31 January 2019

## **The Star - MOD 13 (MP08\_0098 MOD13)**

### **Response to City of Sydney comments to the Response to Submissions**

Figure 14. Proposed Stormwater Works On Edward Street

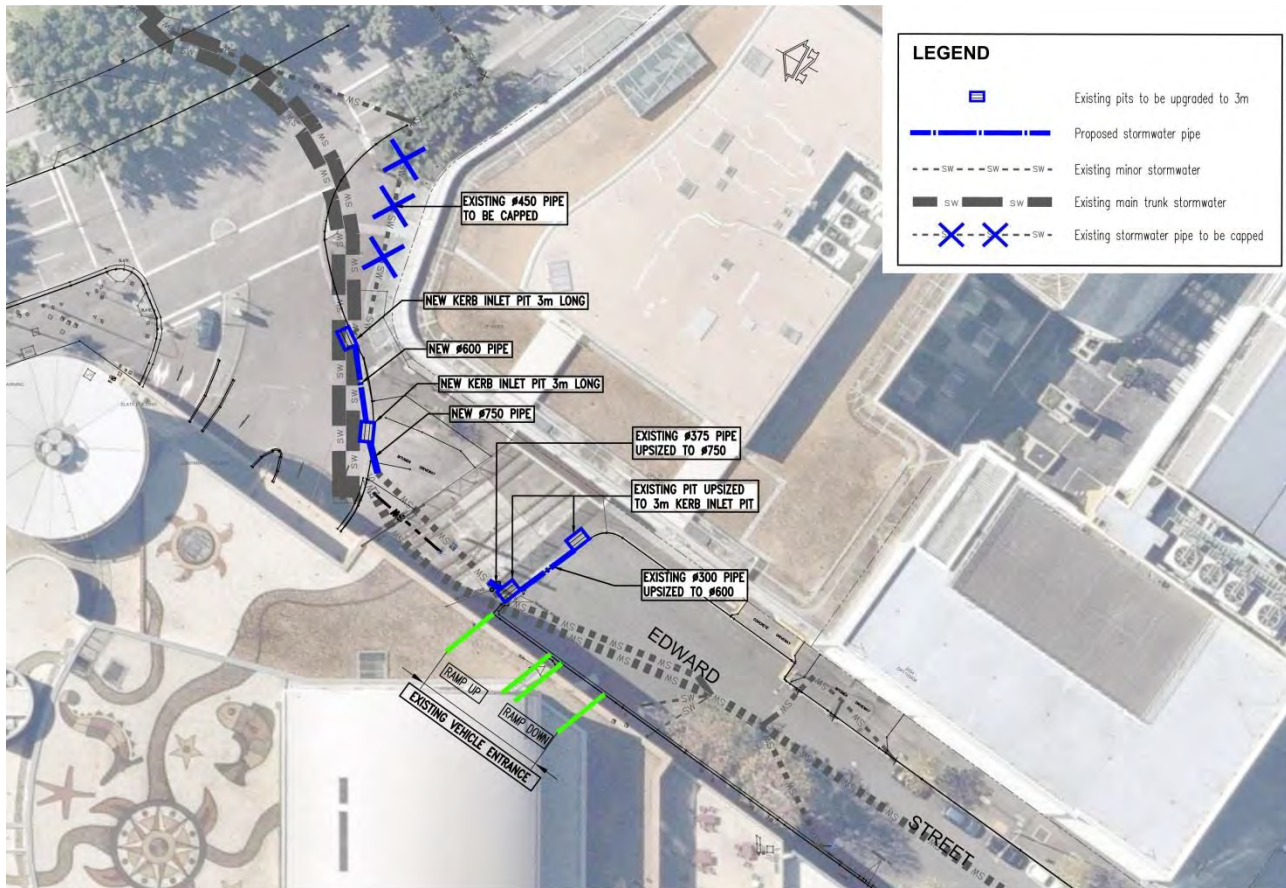
*Similar to the above comments regarding Stormwater, a copy of the “TTW Flood Impact Assessment (January 2018)”, including all the assumption and parameters/limitation of this report, is not available for review. On this basis, the City is unable to properly review and provide any comments on the proposed stormwater works to address the local flooding and overland flow issues.*

**The original TTW Flood Impact Assessment, January 2018, was included as appendix DD of the Environmental Impact Assessment, which was submitted for approval on 13.08.2018 and is available on the NSW Planning and Environment website.**

**The flood impact assessment and addendum confirm the proposed development has no detrimental impact on flooding. The proposed flood mitigation works reduce the 1% AEP flood depth, reduces the flood risk and flood hazard to the development, adjacent properties and the public, and are in accordance with CoS Interim Floodplain Management Policy.**

Figure 17. Proposed 100 Year ARI Flood Depth on Edward Street (flood depth<100mm not shown)

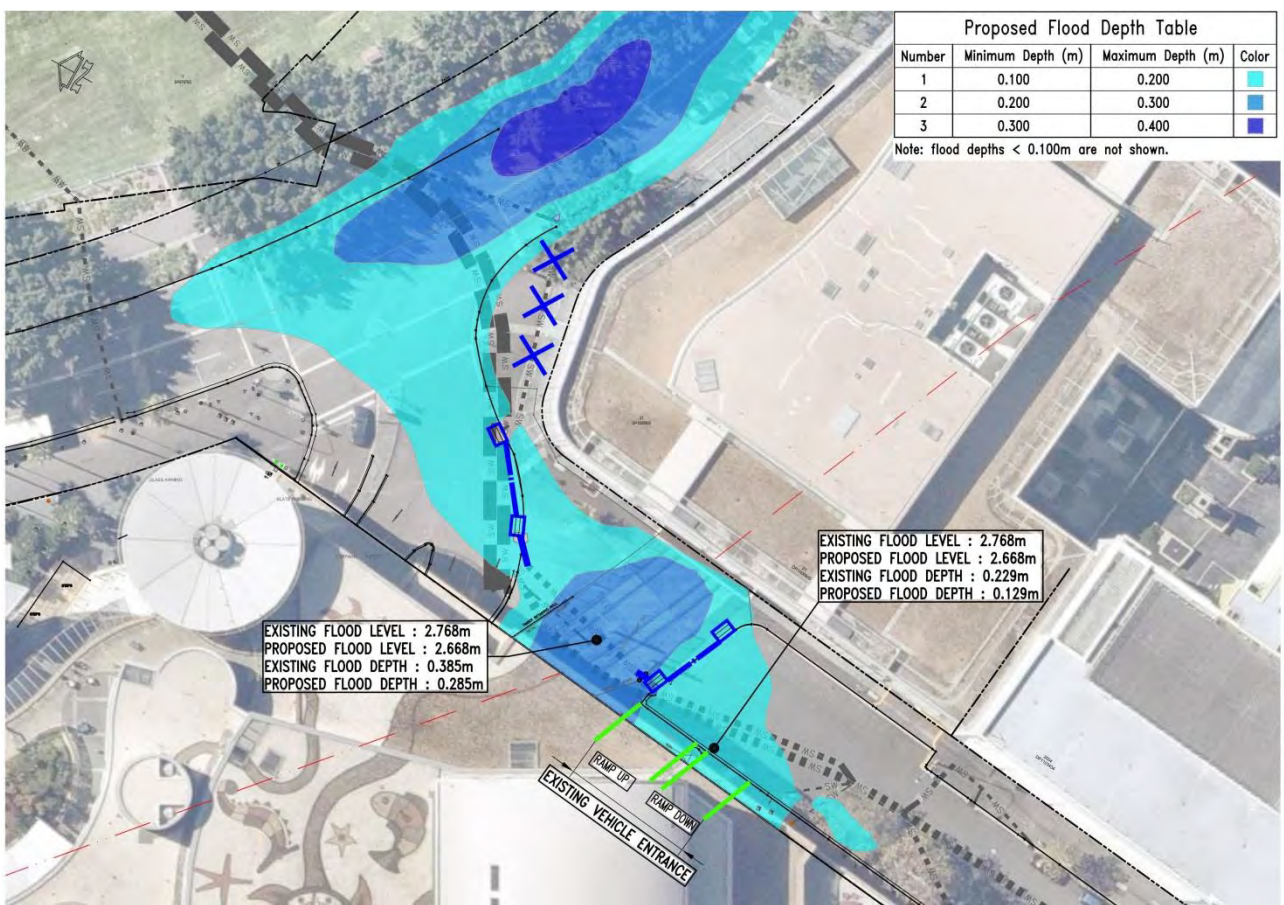
Nevertheless, it is expected that the revised flood impact assessment addendum prepared by TTW dated 07.11.2018 should demonstrate that the proposed and existing FFL comply with Council's Interim Floodplain Management Policy, and include a plan showing the FFL, existing kerb and 1%AEP, and PMF.

Plans that show the extent of flooding, levels and depths are included below (refer to section 4.3 - pages 19 and 20 of the January 2018 Flood Impact Assessment and refer to page 5 of the November 2018 Flood Impact Assessment Addendum):

Figure 17. Proposed 100 Year ARI Flood Depth on Edward Street (flood depth<100mm not shown)

1% AEP flood depths around the site are less than 100mm (below top of kerb height) other than at the low point in Pyrmont Street and Edward Street. As the development use is Retail and Business, the Flood Planning Level is taken as the 1% AEP (100 year ARI) flood level. This Flood Planning Level is achieved as the building is above top of kerb level.

No changes are proposed for the existing basement entrance on Edward Street however this existing entrance will be protected up the flood planning Level (1% AEP + 0.5m) with the use of automatic self-closing flood gates.
